RE: PLANNING APPLICATION FP/109/11

Resubmission following refusal of FP/241/10 and FP/155/09

1 Detached Bungalow with Associated Parking and External Works.

21, Uppark Way, Flansham Park, Bognor Regis, West Sussex, PO22 6QQ.

Project Land Adjacent 21 Uppark Way **Drawing Title** Planning **Drawing No** 508/DPA02 **Rev** 04

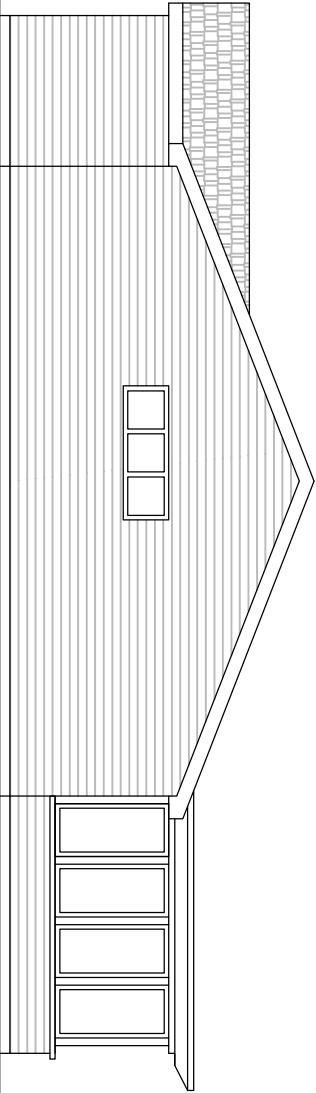
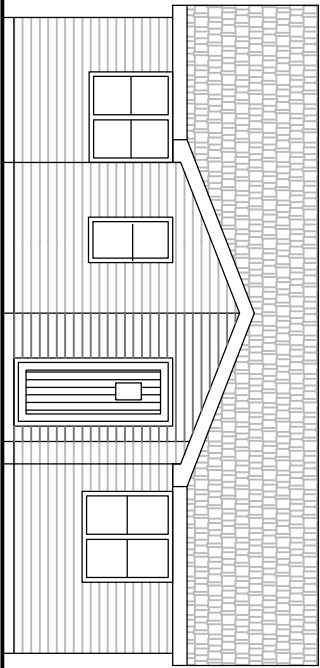
It looks as if the North and South Elevations seem to be wrong yet again. There does not appear to be a retaining wall to hold up our side of the hump, which will fall down if it is not retained. The proposed new bungalow is not in keeping with the existing properties, it is a totally different style to what is already in the road.

The Plans once again show anomalies. **PROPOSED FLOOR PLANS AND ELEVATIONS Drawing No 508/DPA02 shows the SOUTH ELEVATION facing the wrong way.** It may only be a small point but to us shows a complete lack of competence on the preparation of the plans.

PROPOSED SITE AND ROOF PLAN

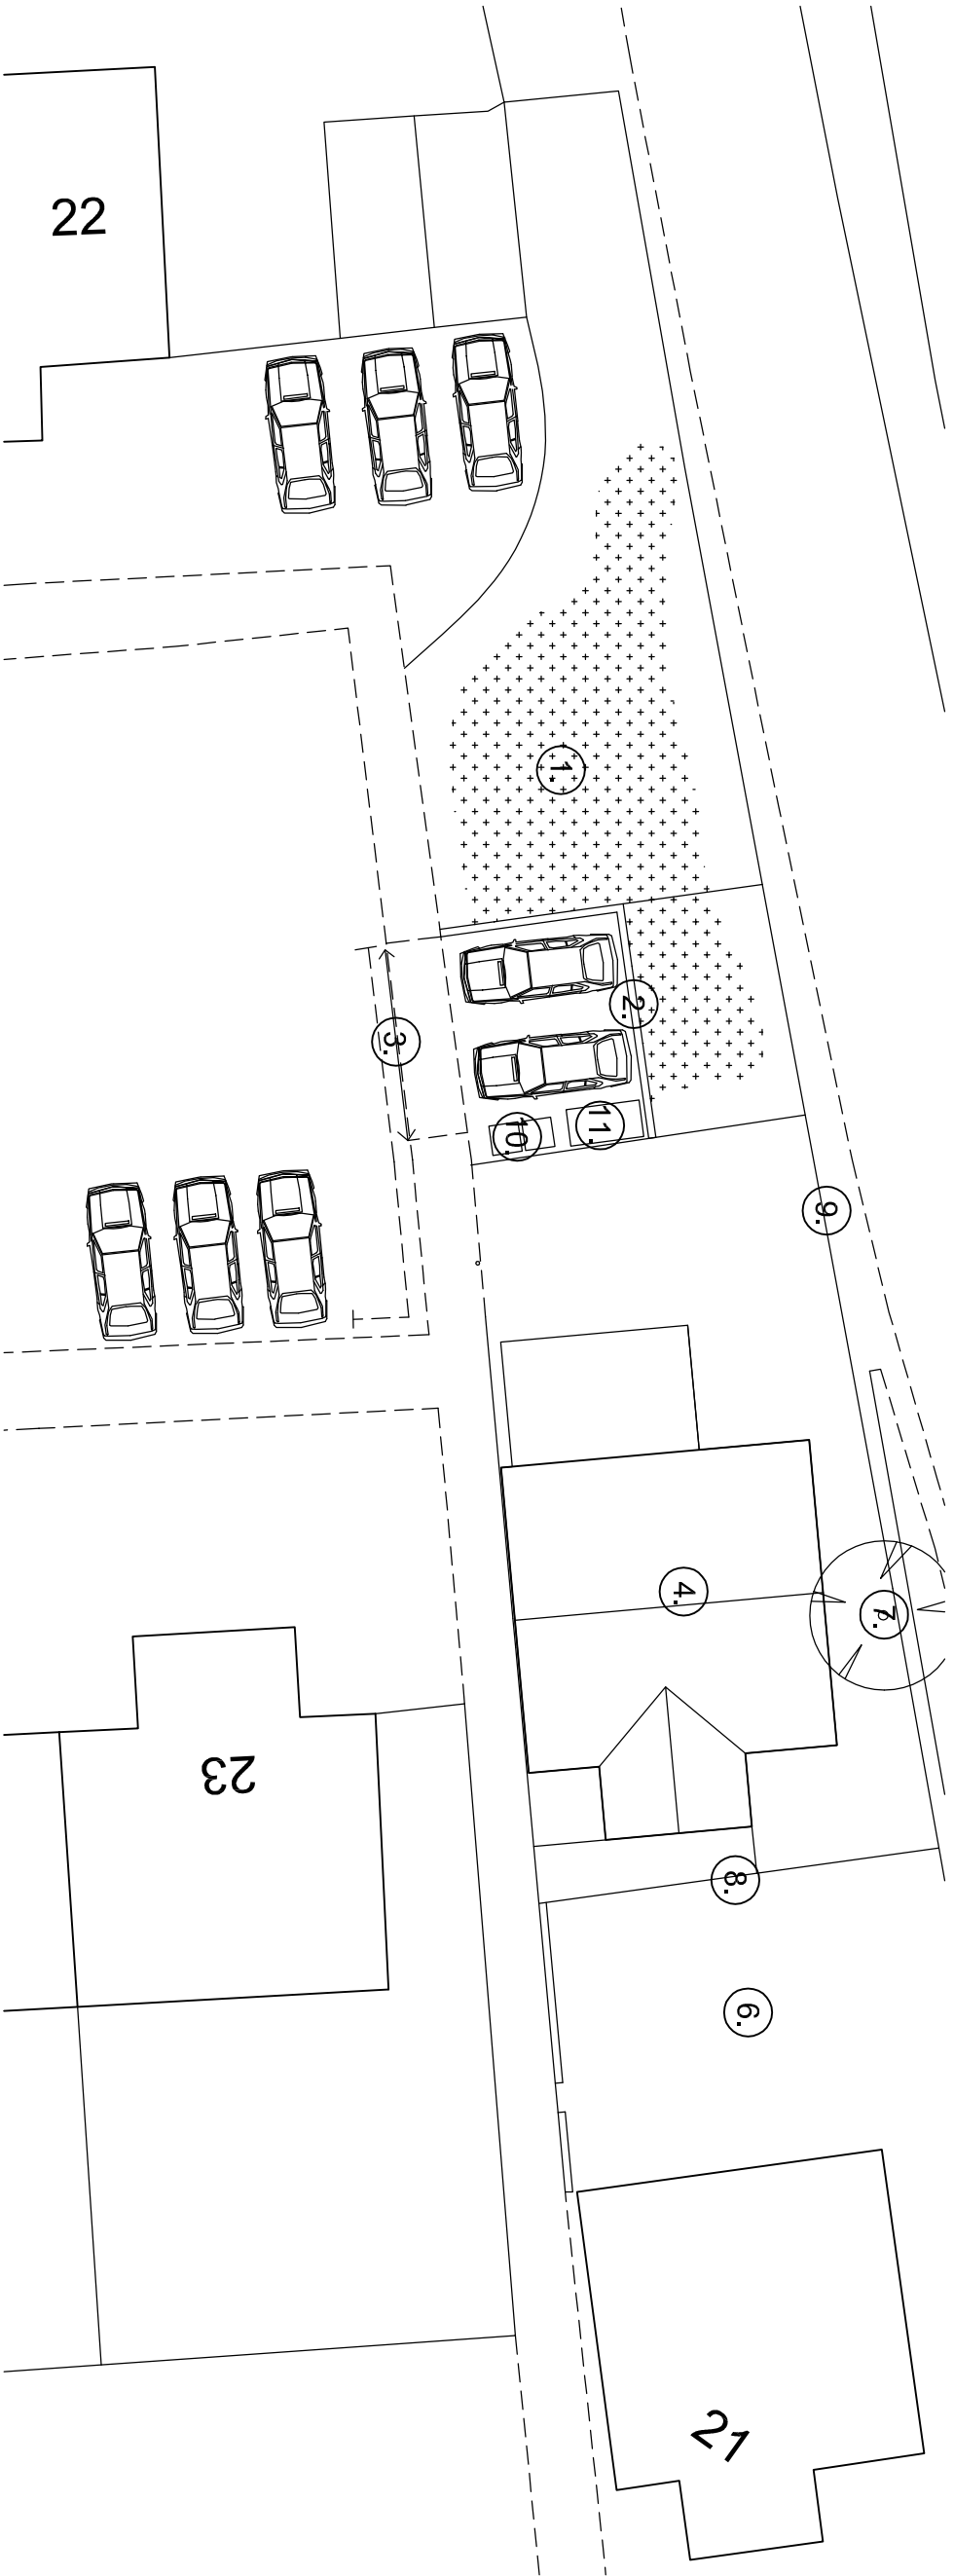
The eastern side of the grass banked landscaped area situated at the northern end of Fittleworth Drive [irrespective of being owned by the present owner occupiers] is not, and never has been, part of the rear garden of 21 Uppark Way but yet again the plans show that the land required for this development includes half of the grass bank irrespective of the conclusion given by the planning department in refusing the previous application which stated when referring to the grass banked area:

Drainage remains a problem as stated in the past 2 objections to building on this site and the plans show that the building line is NOT outside the required 3 metres of a main sewer.

The building still seems to be not 3 metres away from the main drains which we understand is a legal requirement. The application also states that they do not know whether they intend to connect to the main drainage system, should they not know what their intention is? Our property is regularly suffering from blocked sewers when our toilet backs up and we are unable to flush for many hours or until the water company clears the problem. We note there intends to be a soakaway on the new proposed bungalow, but there does not appear to be enough room for this.

The plans show quite clearly that any building work will **NOT** be outside the 3 Metres required to build near a mains sewer.
